Date: 8 July 2026
PINS Ref: EN0710010
Our Ref: 17996

EN0710010 – EAST COAST HYDROGEN TEESSIDE PIPELINE (NORTHERN GAS NETWORKS)

We write on behalf of Net Zero North Sea Storage ('NZNSS'), in respect of Northern Gas Network's ('NGN' / the 'Applicant's') proposed development consent application for the East Coast Hydrogen Teesside Pipeline Project (the 'ECH Teesside Project'). NZNSS is an undertaker for the purposes of the development consent order granted in respect of the Net Zero Teesside Project.

Scoping Boundary

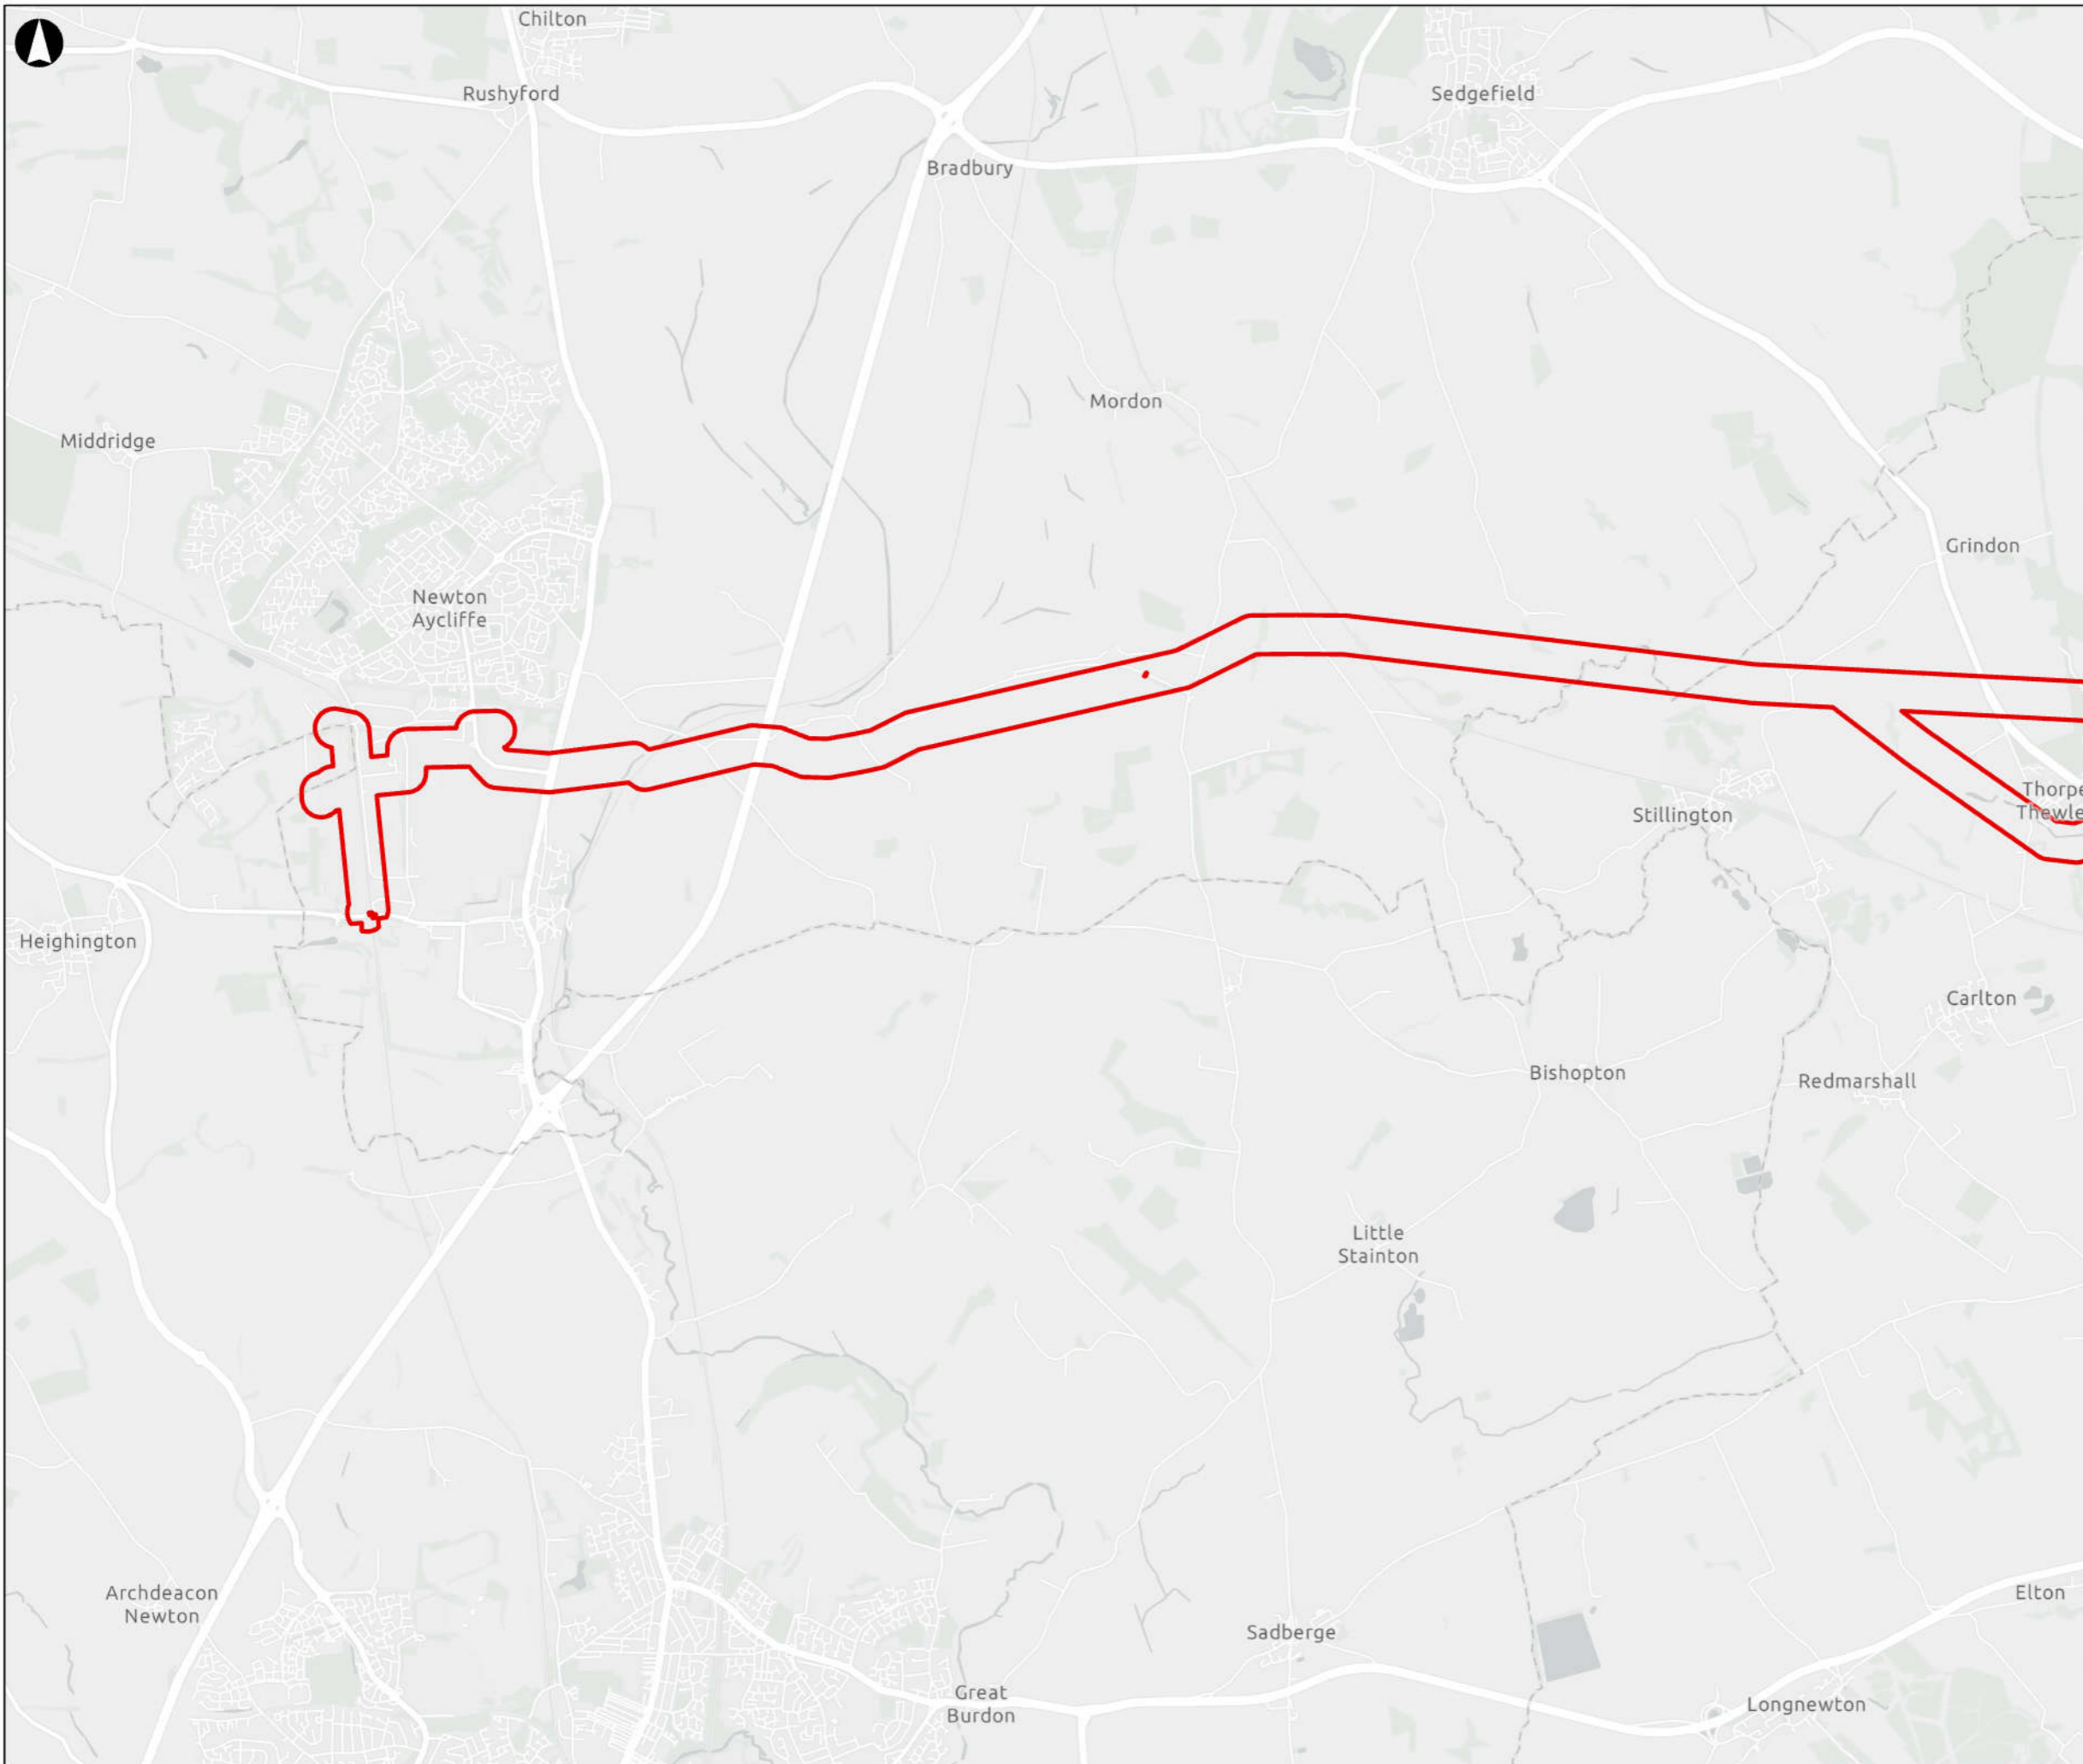
NZNSS notes that NGN has submitted an application for an Environmental Impact Assessment ('EIA') scoping opinion in respect of the ECH Teesside Project to the Secretary of State for Energy Security and Net Zero. We have reviewed the EIA Scoping Report, notably Figure 1.2 (Rev P01) and Figure 1.3 (Rev P01) which show the Scoping Boundary, and Figure 4.1 which shows the Indicative Site Layout, and wish to make you aware of the interactions and overlaps of those with the confirmed Order limits for the Net Zero Teesside Project.

It is evident from a review of the ECH Teesside Project's EIA Scoping Report and the NZT Works Plans, that there are significant interactions and overlaps between NGN's Scoping Boundary (Figures 1.2 and 1.3) and the NZT Order limits for the NEP Project. In particular, the proposed Scoping Boundary for the ECH Teesside Project, includes land that is within (or is in close proximity to) the carbon dioxide gathering network (Work No.6); and above ground installations (Work No. 6A) within the confirmed Order limits for NZT.

Having regard to the above, it is crucial that the Order limits for the NEP Project are taken into account by NGN in undertaking its EIA of the ECH Teesside Project, and that the ECH Teesside Project does not impact on the delivery of the NEP Project given its importance within the ECC. It will be of significant interest to NZNSS as to how the Applicant plans to install the infrastructure comprising the ECH Teesside Project while protecting, and facilitating ongoing future access to NEP's infrastructure. NZNSS is also concerned that the ECH Teesside Project may have a safety impact on NEP. Given these
